Response from Necton Parish Council to the Letter from the Secretary of State, Issued on 5th July (and the following letter extending the deadline for responses), Requesting Comments by Interested Parties on the Submissions Made by the Applicant Concerning the Vanguard DCO
(Your reference number: ENO-10079).

Necton Parish Council
17 November 2021

Drawing file: EN010079 / EN010079-001897-Figure 29.09 Indicative Onshore Project Substation Mitigation Planting.pdf

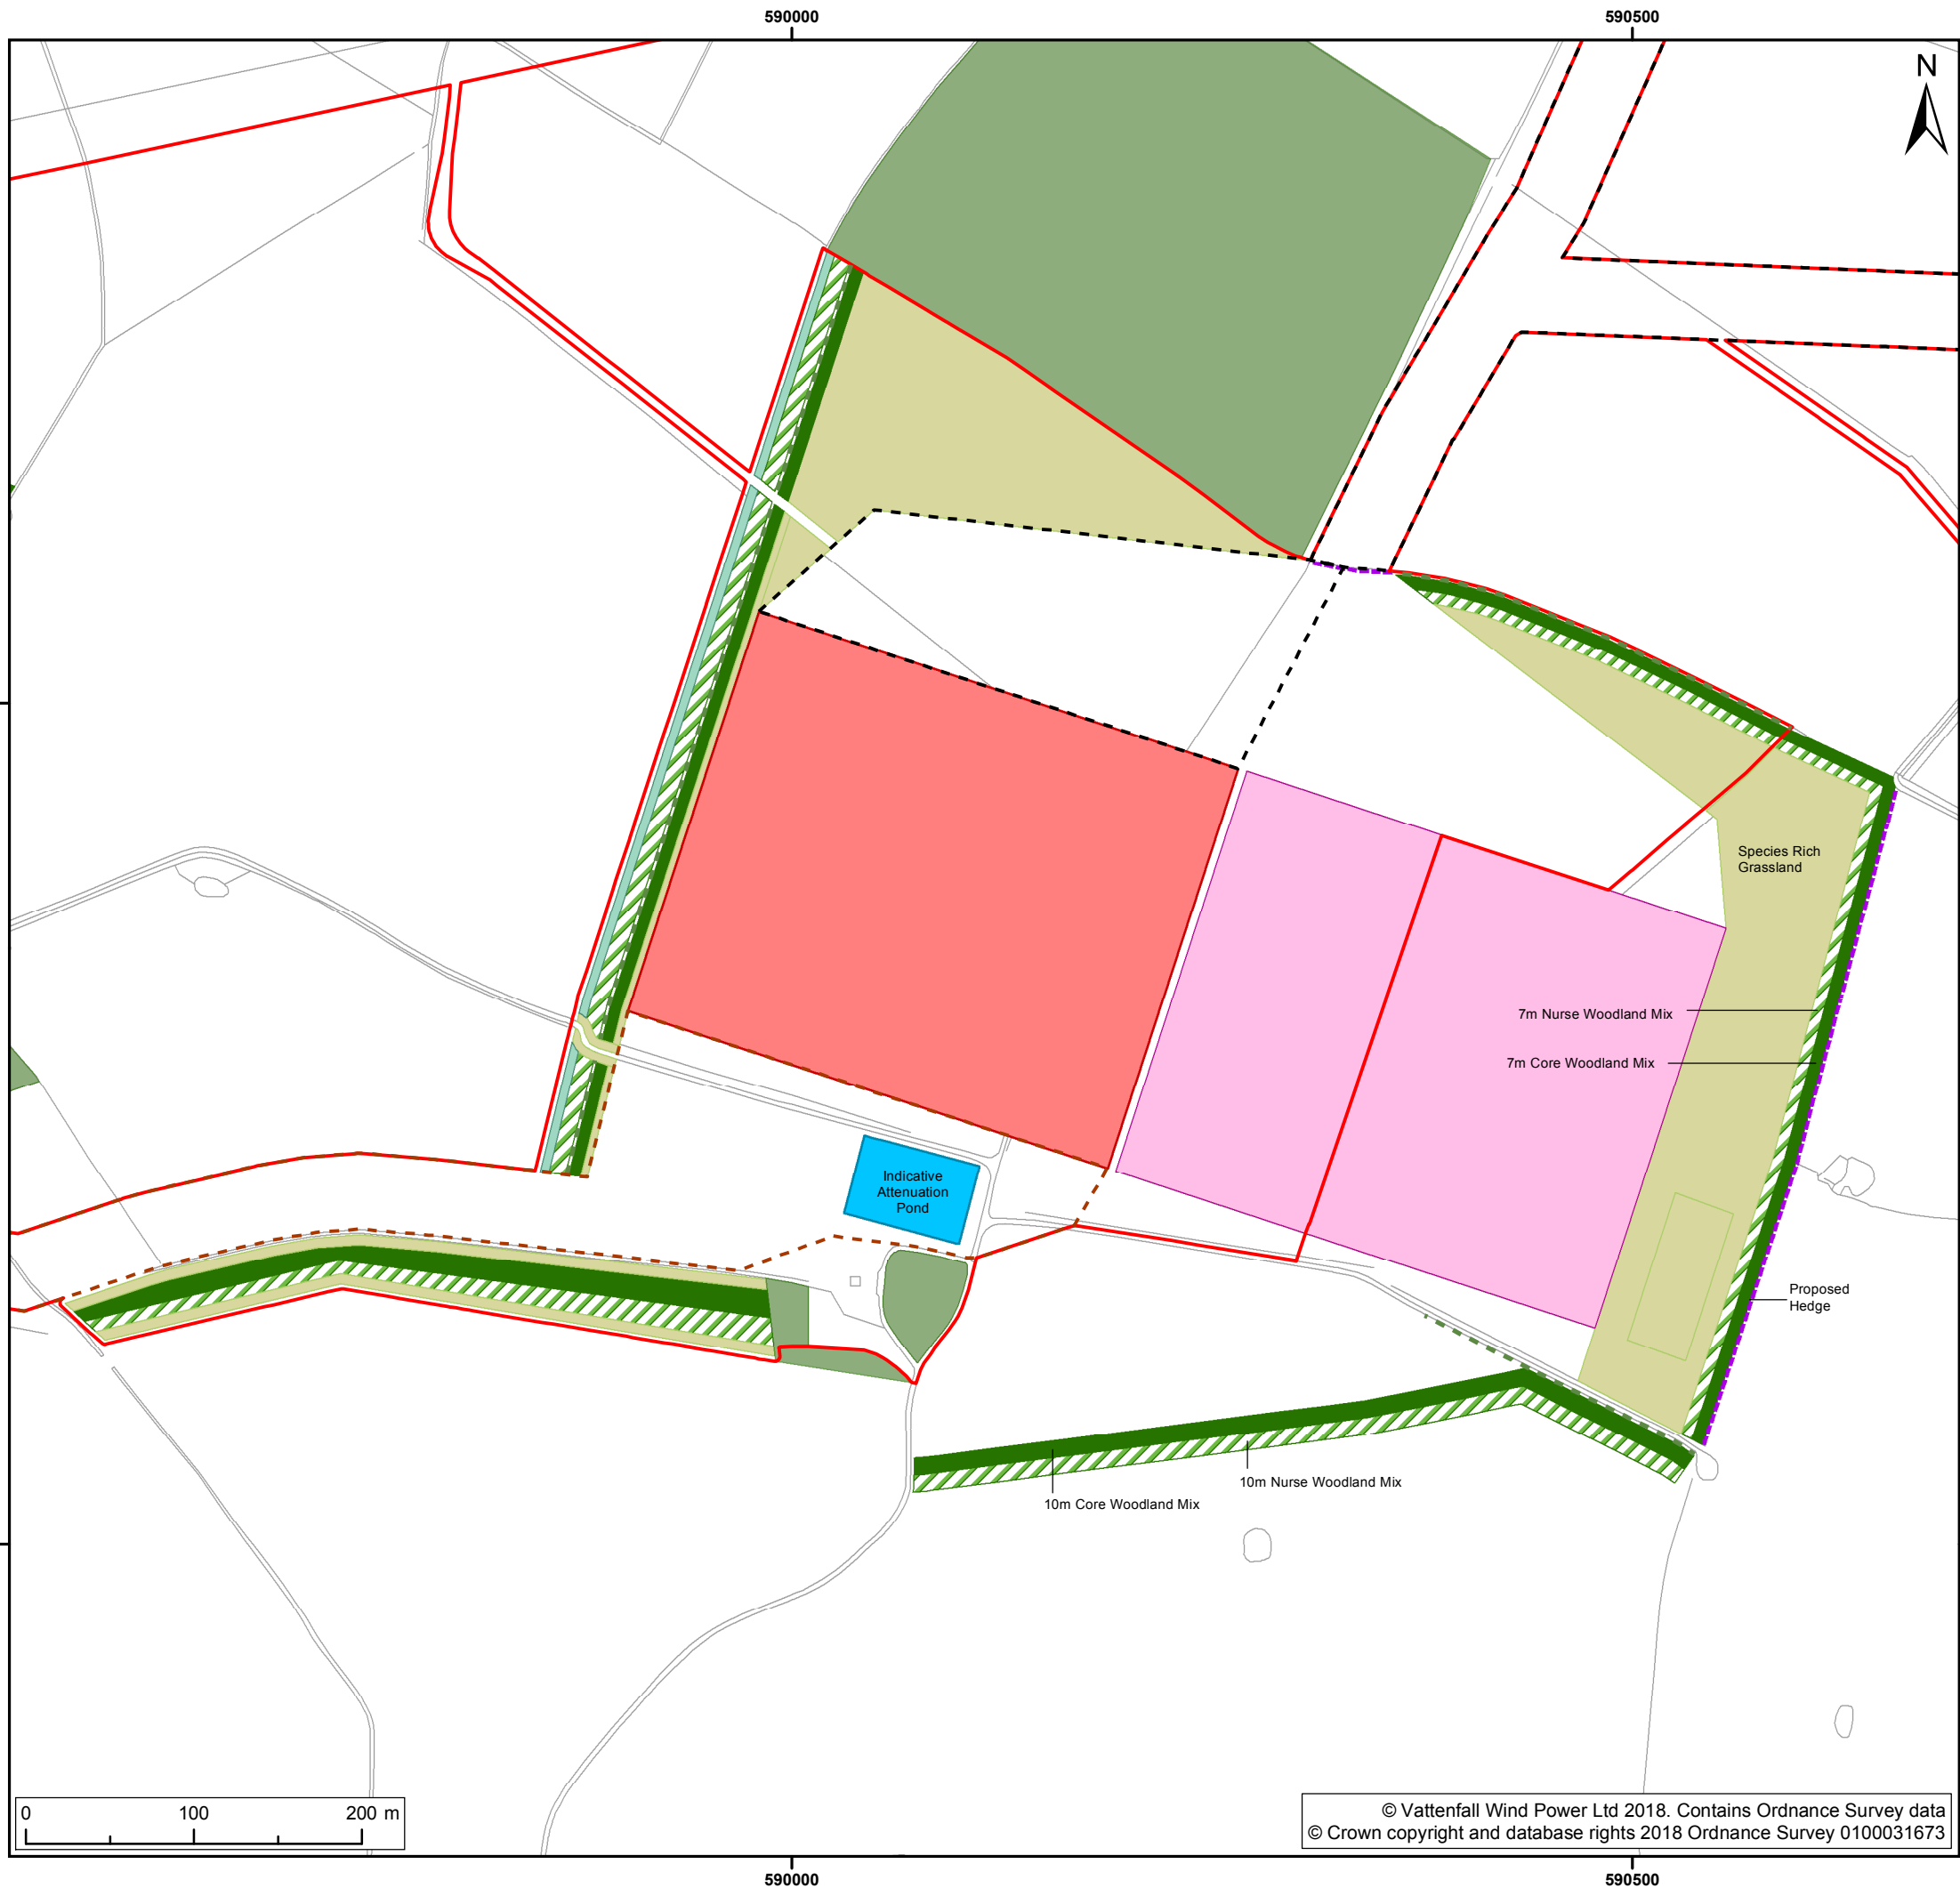
2. The mitigation proposed for a project lifespan of 25 years and buildings 19 metres high, is tree planting that will not mask the buildings for at least 90% of the life-span of the project. This is woefully inadequate.
